Local Policing Support Team

RE: Land South Of The Littlehampton Academy Fitzalan Road Littlehampton BN17 6ED

Thank you for your correspondence of the 20th of April 2021, advising me of a planning application for Erection of 112 No. residential units with access from Fitzalan Road, open space, hard and soft landscaping works, internal roads/footways, car and cycle parking, substation, bin store and associated engineering and infrastructure works. This site is in CIL Zone 4 & is CIL Liable as new dwellings at the above location, for which you seek advice from a crime prevention viewpoint.

7.02 PARKING AND REFUSE PROVISION

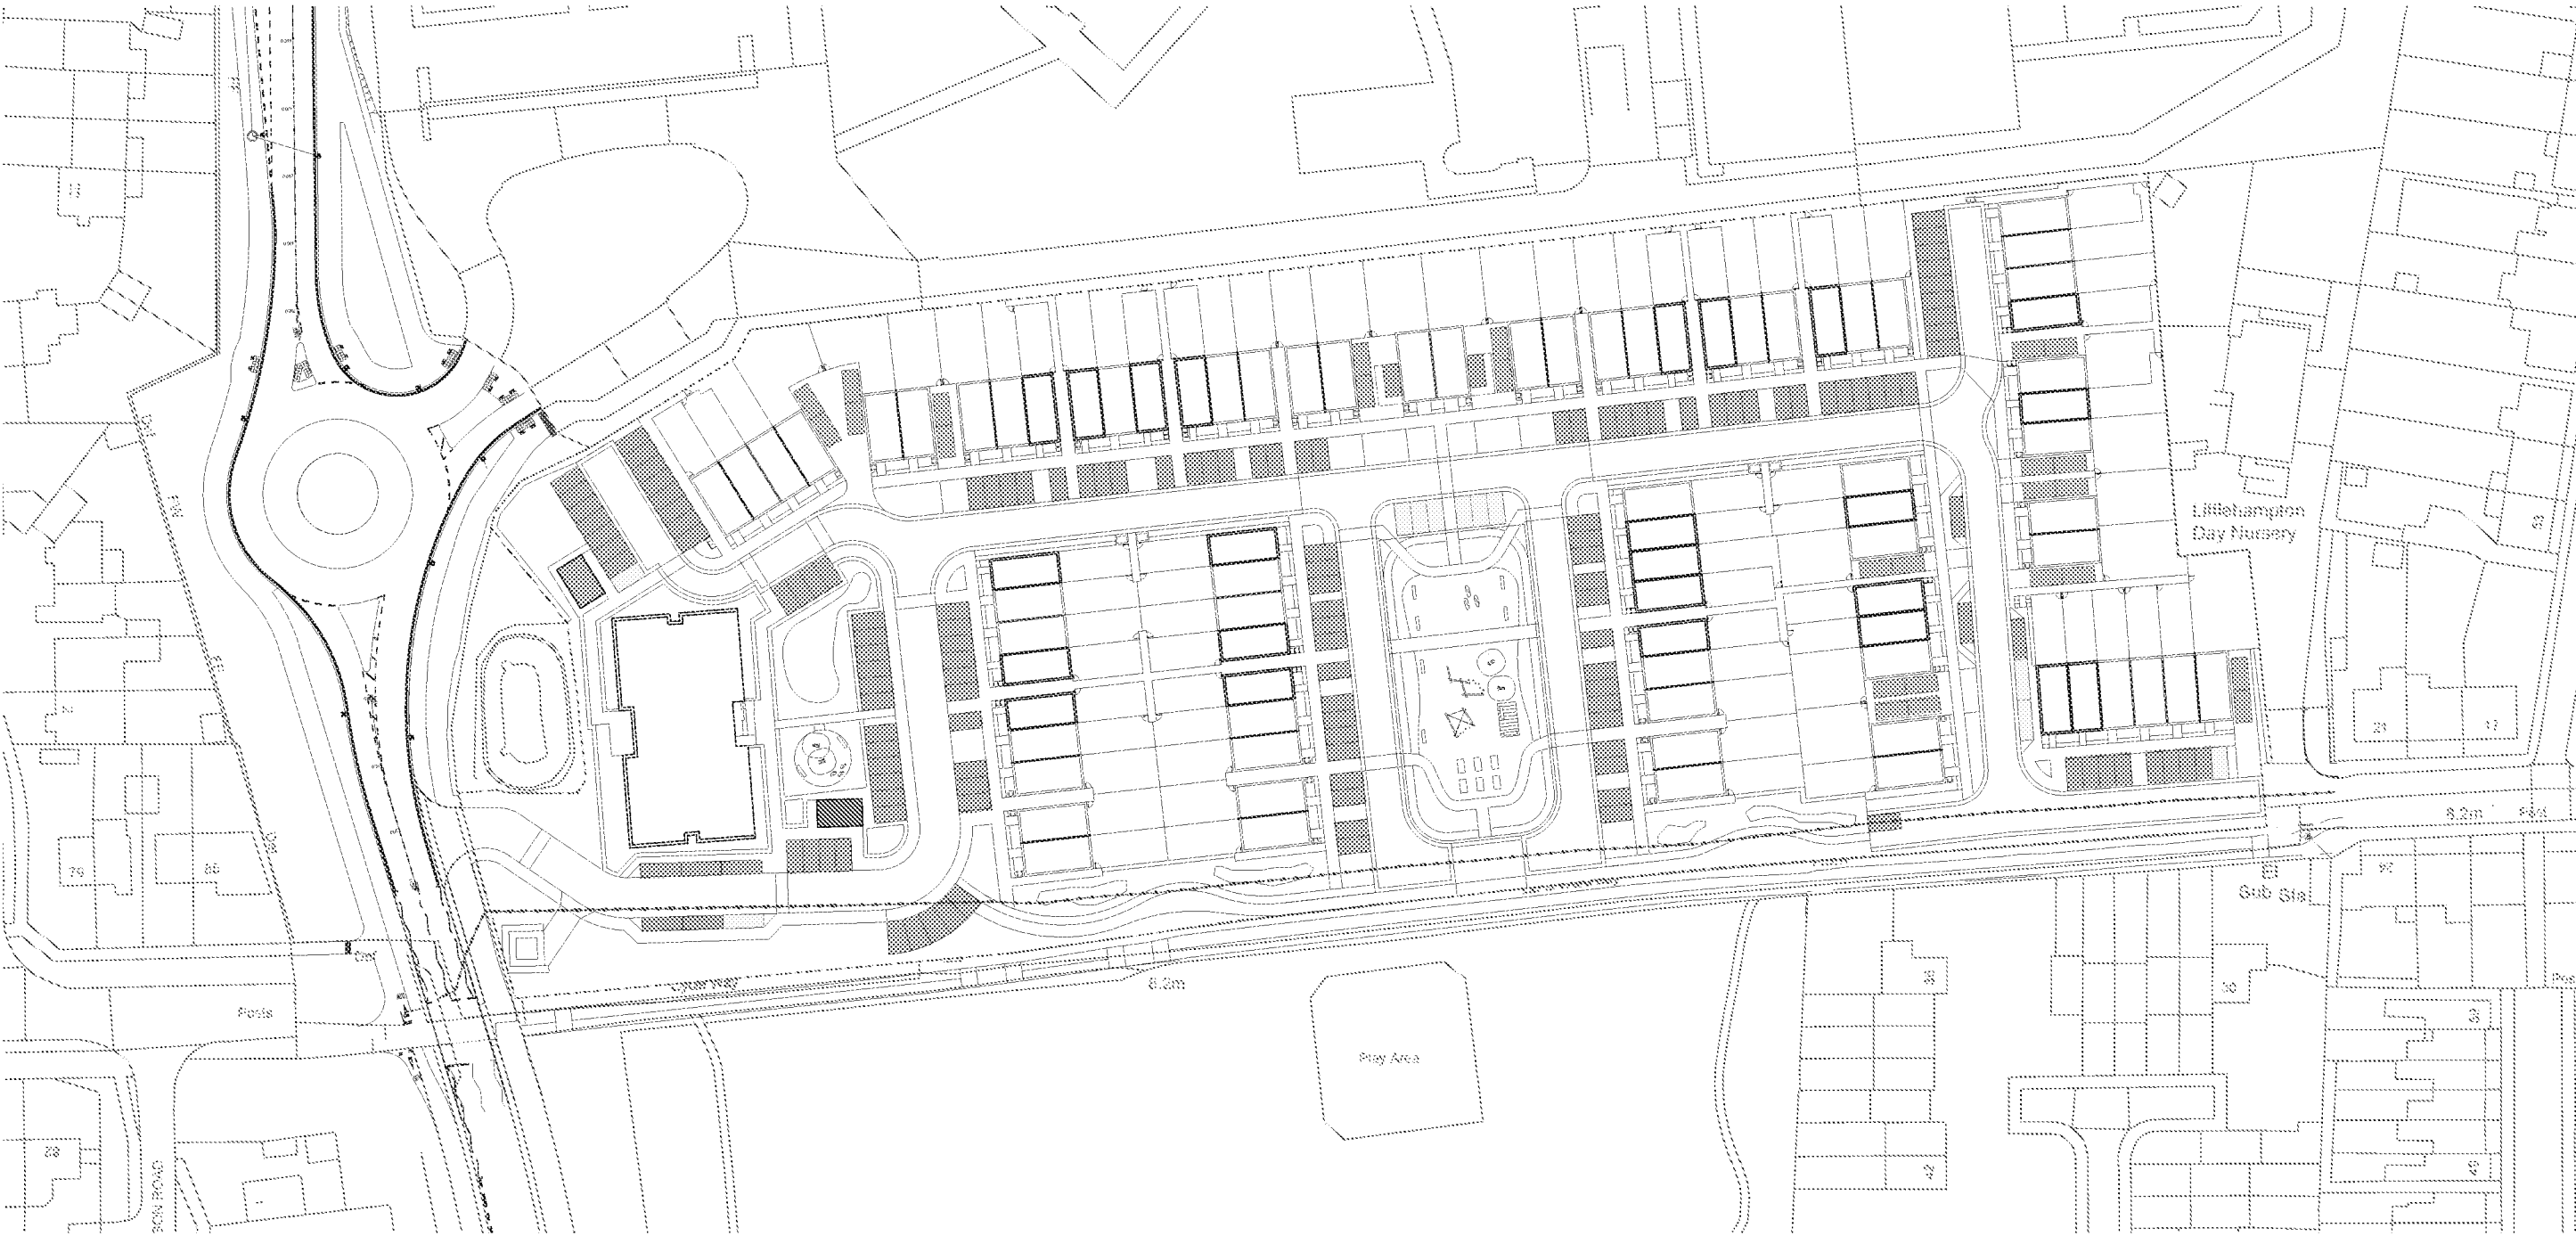
Where parking occurs within the development it is important that they must be within view of an active room within the property. An active room is where there is direct and visual connection between the room and the street or the car parking area. Such visual connections can be expected from rooms such as kitchens and living rooms, but not from bedrooms and bathrooms.

7.10 APARMENT - BLOCK - A_2C2_4

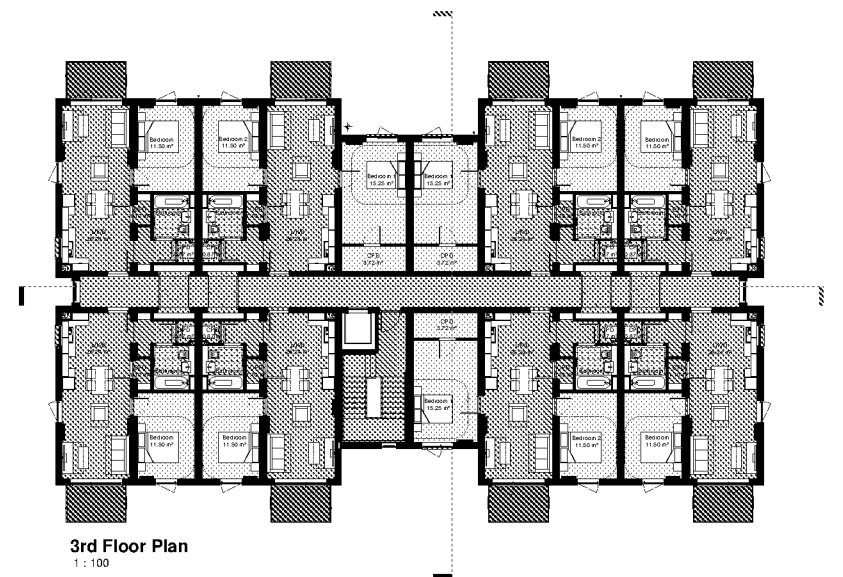
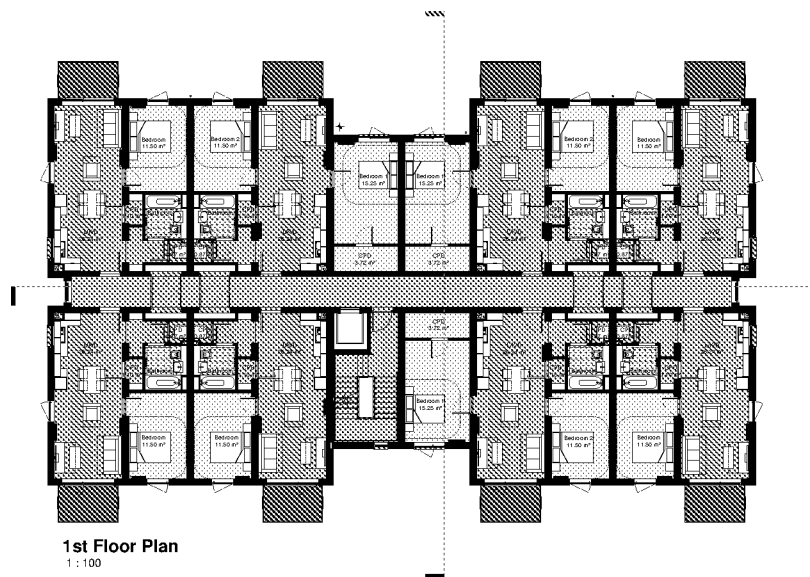
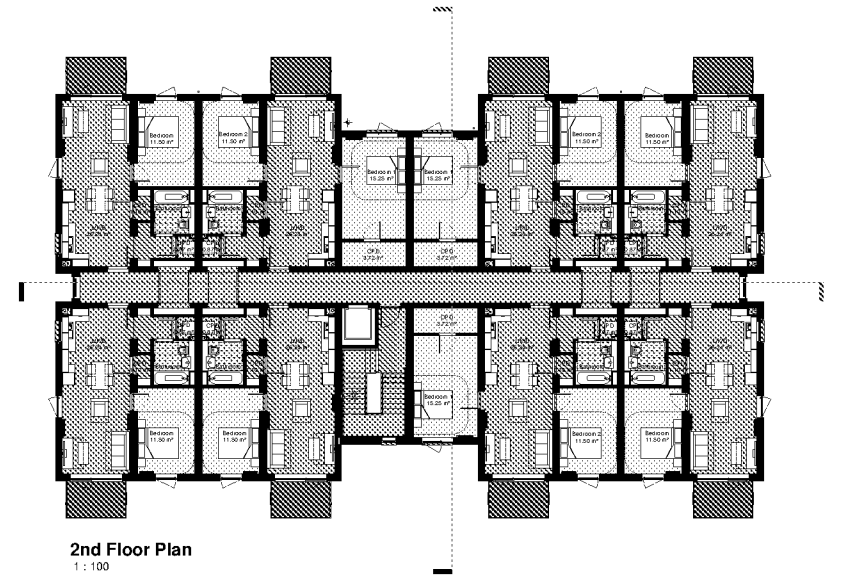
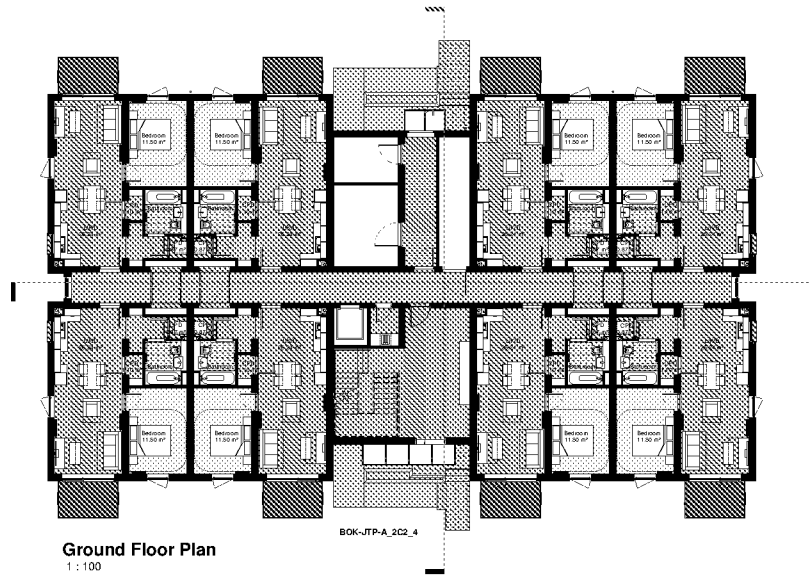
From a crime prevention perspective to any proposed flats, it will be imperative that access control is implemented into the design and layout to ensure control of entry is for authorised persons only. SBD recommends that all communal door-sets serving 5 or more dwellings or bedrooms should have visitor door entry system or access control system to enable management oversight of the security of the building i.e. to control access to the building via the management of a recognised electronic key system. It should also incorporate a remote release of the primary entrance door set and have audio visual communication (preferably colour) between the occupant and the visitor. I refer the applicant to SBD Homes Version 2 2019 Chapter 27 for further information. Tradesperson or timed release mechanisms are not permitted as they have been proven to be the cause of antisocial behaviour and unlawful access to communal developments.

Additionally, I recommend the postal arrangements for the flats is through the wall or externally mounted secure post boxes. I strongly urge the applicant not to consider letter apertures within the flats' front doors. The absence of the letter aperture removes the opportunity for lock manipulation, fishing and arson attack and has the potential to reduce unnecessary access to the block.

Developments over 25 flats/apartments can suffer adversely from anti-social behaviour due to unrestricted access to all areas and floors of the building. In order to create a safe and secure communal environment for residents occupying blocks of multiple flats, and to reduce the opportunity for antisocial behaviour by restricting access to all areas and floors of the building to all residents SBD seeks to curtail unlawful free movement throughout the building through the use of an access control system (compartmentalisation).

- Controlled lift access – each resident is assigned access to the floor on which their dwelling is located via the use of a proximity reader, swipe card or key. Fire egress stairwells should also be controlled on each floor, from the stairwell into communal corridors, to reduce the risk of them being used for anti-social behaviour or criminal activities.
- Dedicated door-sets on each landing preventing unauthorised access to the corridor from the stairwell and lift; each resident being assigned access to the floor on which their dwelling is located.
